Crossways, Lower Pennington Lane, Pennington, Lymington SO41 8FT

I write in respect of the above site, which benefits from extant planning permission from October 2023 for the demolition of the existing house and the erection of 4 no. houses with access and parking (LPA Ref: 23/10378).

The applicant wishes to make minor amendments to the approved plans, which will improve the quality of the living accommodation within the new dwellings through the construction of dormer windows. Accordingly, the applicant hereby applies for a minor material amendment by virtue of the provisions set out under Section 73 of the Town and Country Planning Act 1990 (as amended) (The 'TCPA 1990').

HOUSE 1

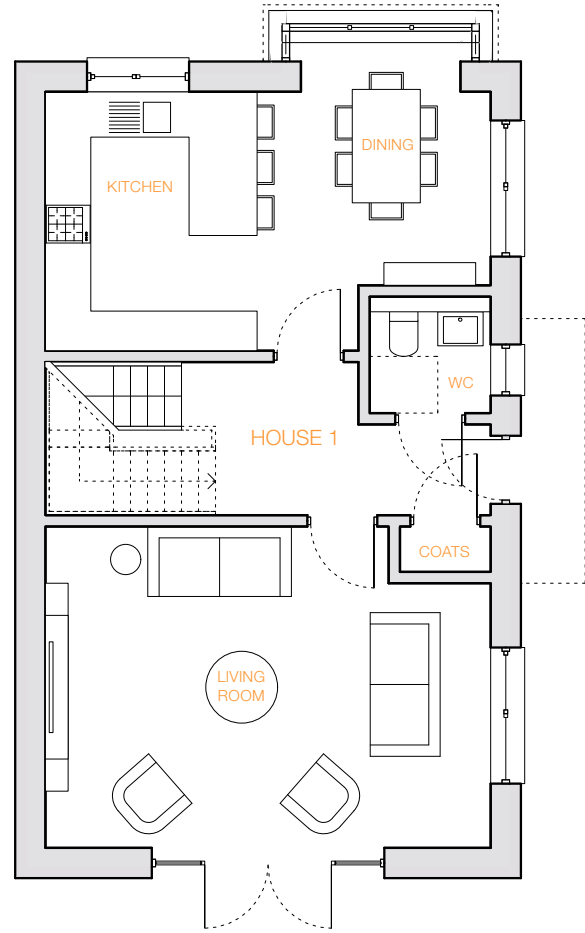
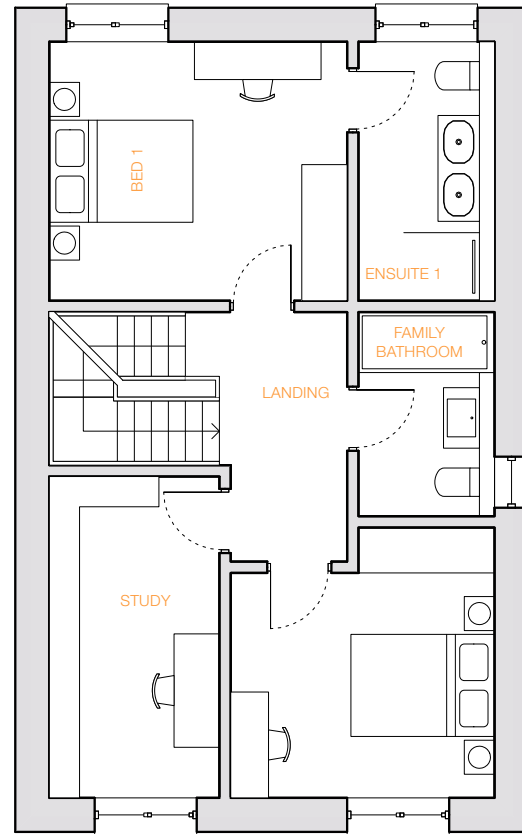
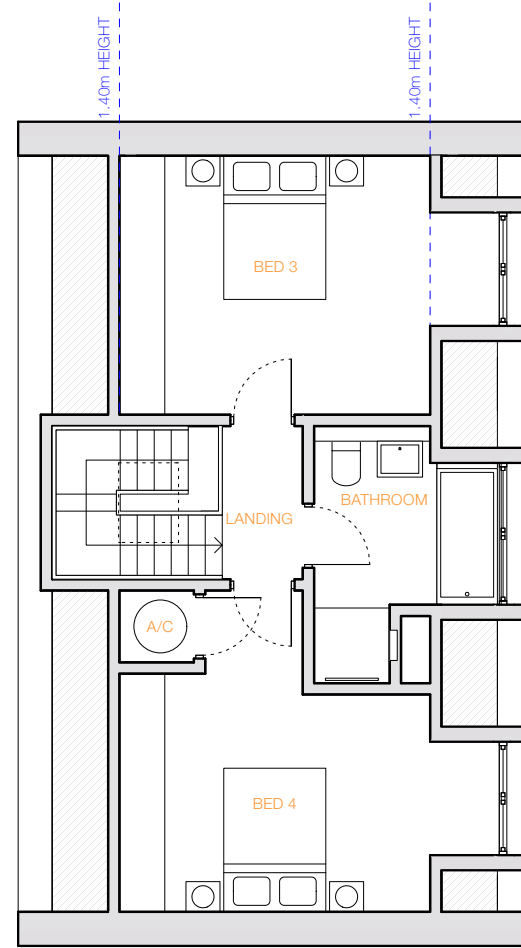
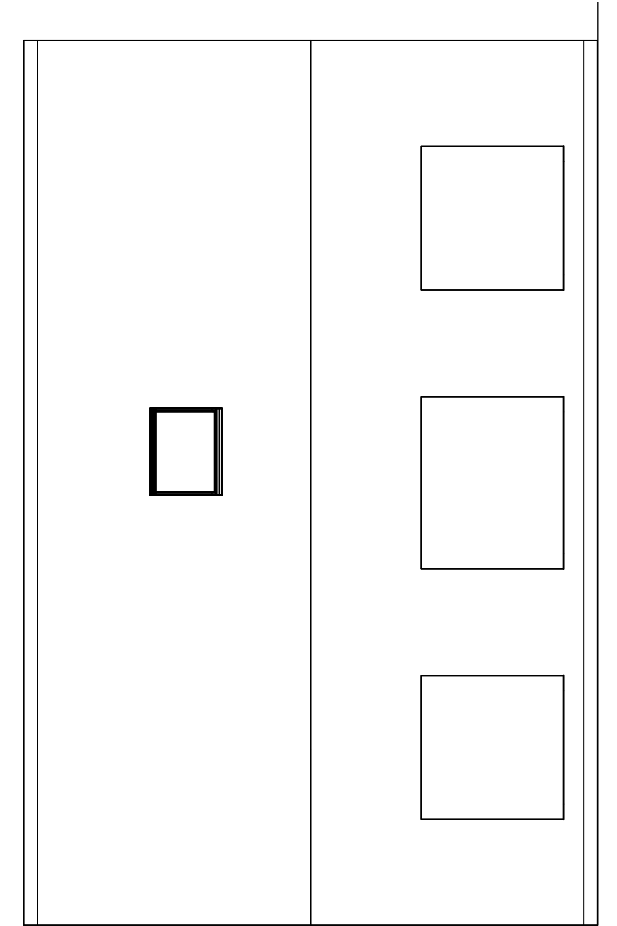
1. Dormer Windows – The extant planning permission permits roof level accommodation within Houses 1, 2 and 3. The approved plans show that the loft rooms within these units would be served by roof lights. House 4 has eaves level dormer windows on the front elevation, which provide first floor accommodation.

The revised elevations and floor plans show that the roof lights to Houses 1, 2 and 3 would be replaced with modest dormer windows. This change would drastically improve the quality of the loft rooms by reducing the amount of floor area with a limited head height, which would improve the living conditions of future occupiers.
